Our ref: HA/2018/120665/01-L01
Your ref: LU/220/18/PL
Date: 05 September 2018

ALTERATIONS & CHANGE OF USE TO EXISTING BANK (A2 FINANCIAL & PROFESSIONAL SERVICES) TO MIXED USE TO RETAIL (A1 SHOPS), OFFICE (B1 BUSINESS), 3 NO. RESIDENTIAL DWELLINGS (C3 DWELLING HOUSE) & DORMER AT SECOND FLOOR LEVEL.

70 HIGH STREET, LITTLEHAMPTON, BN17 5DY.

DWG. NO / 080418 / TP.01 "C"

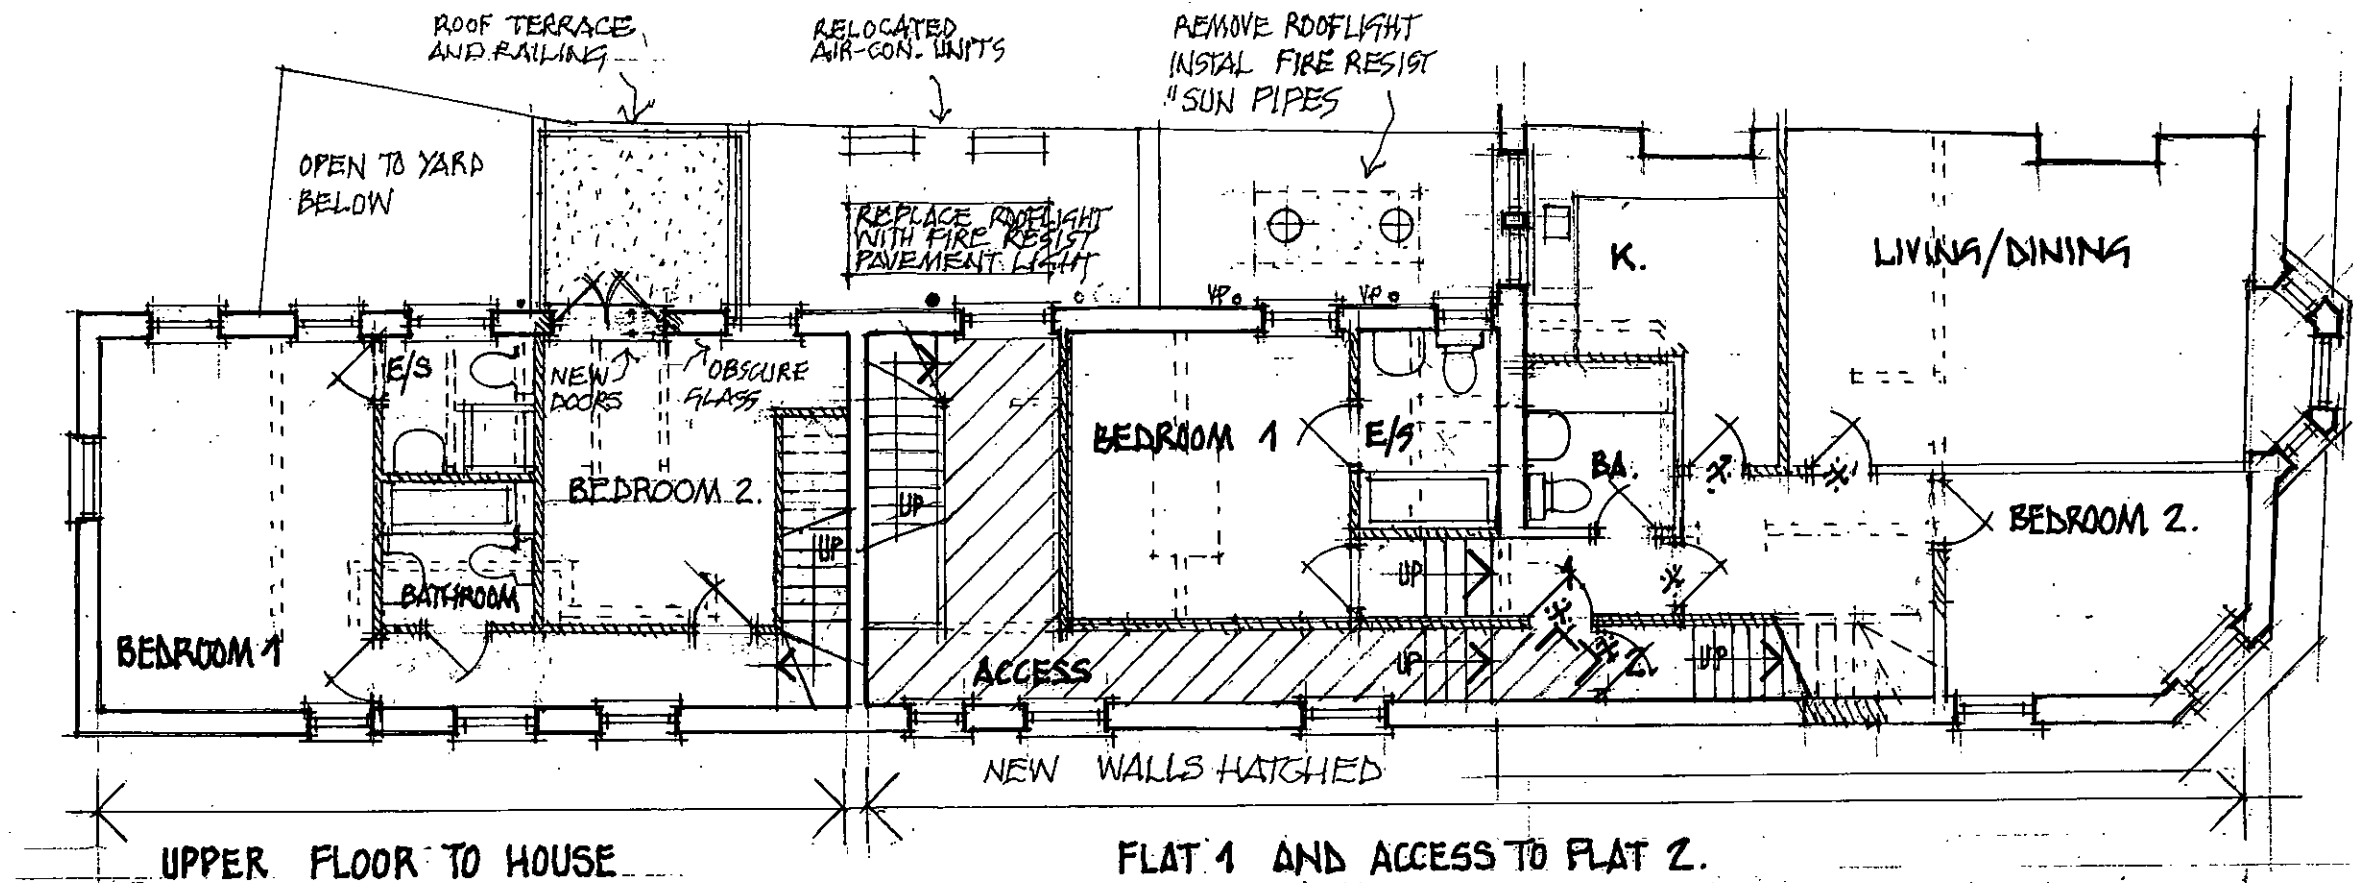
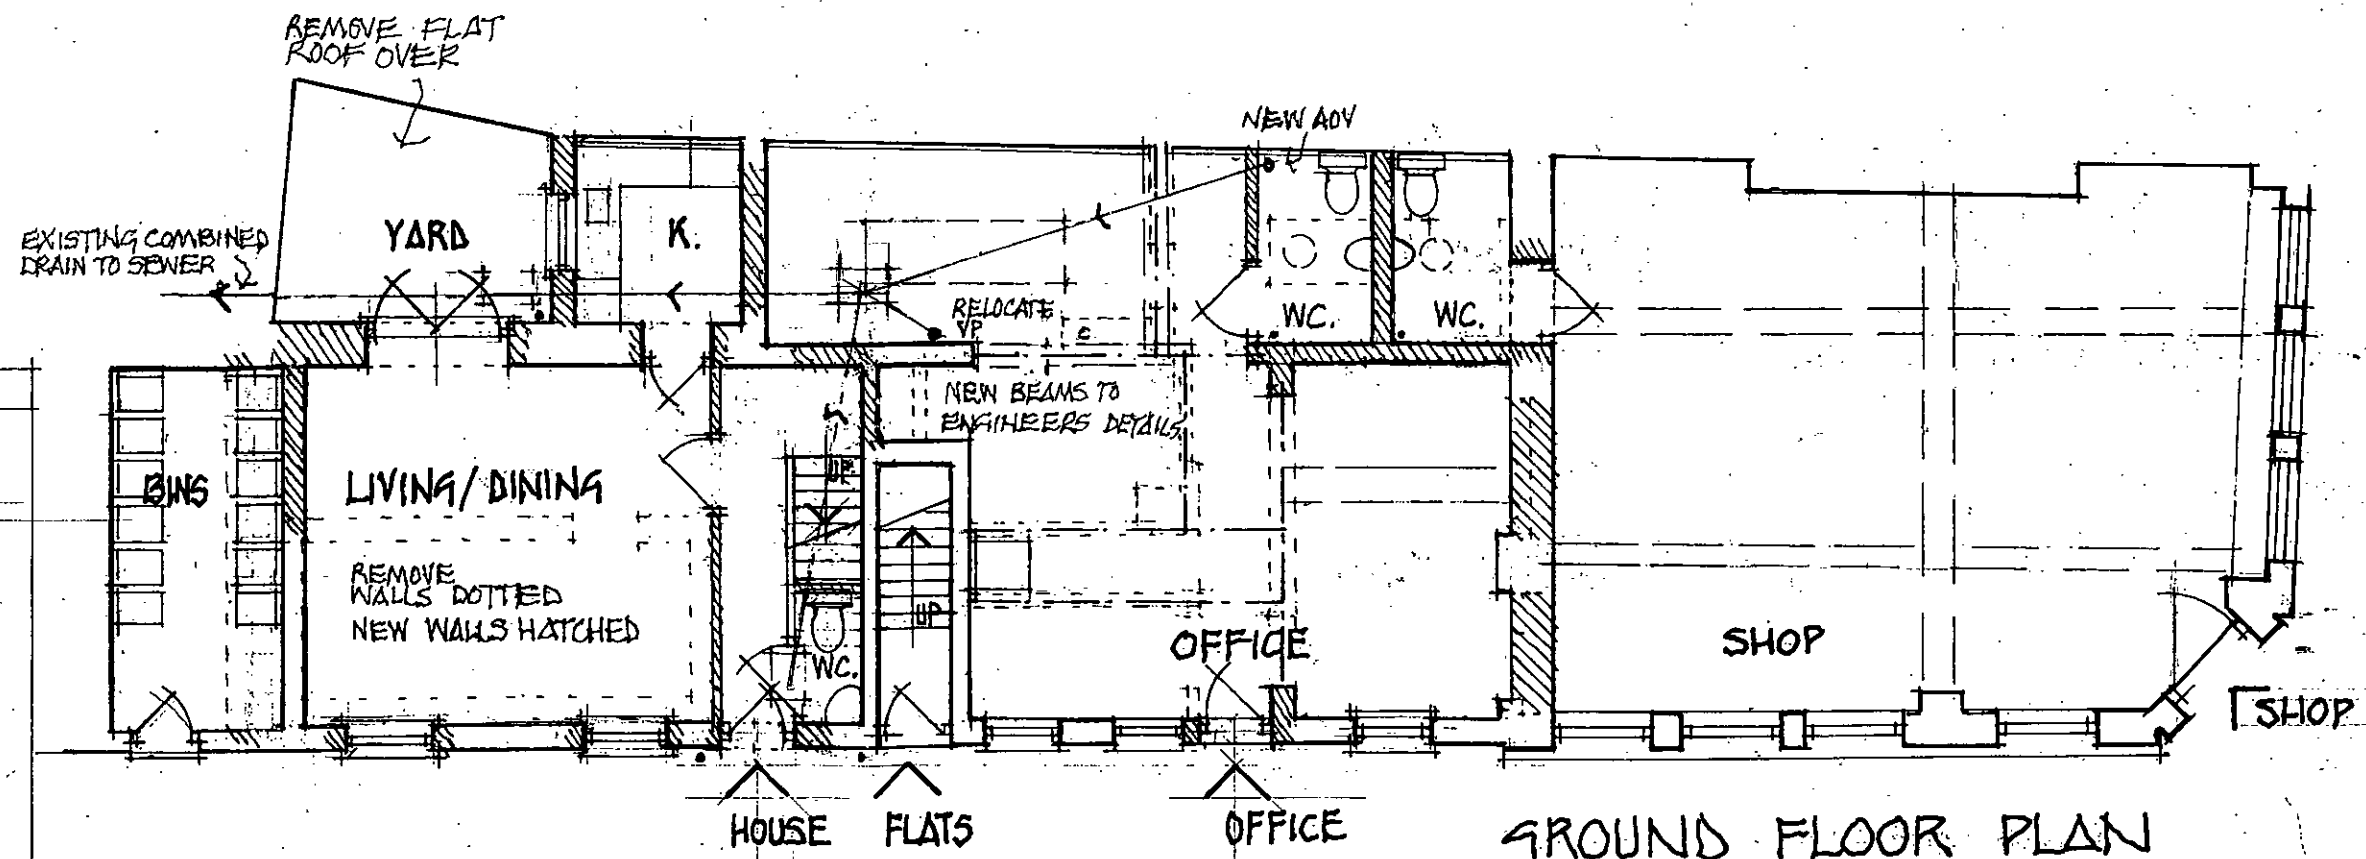
We note that the flood risk information contained in the Design Statement is not sufficient for a Flood Risk Assessment (FRA), and that a suitable FRA should have been provided in accordance with paragraph 163 of the National Planning Policy Framework (NPPF). However, considering this is a change of use, and the majority of the residential dwellings are proposed on the first floor and above so that no sleeping accommodation will be located on the ground floor with safe refuge available at first floor (in accordance with drawing no. 080418/TP01C), we see no reason to object to the proposal.
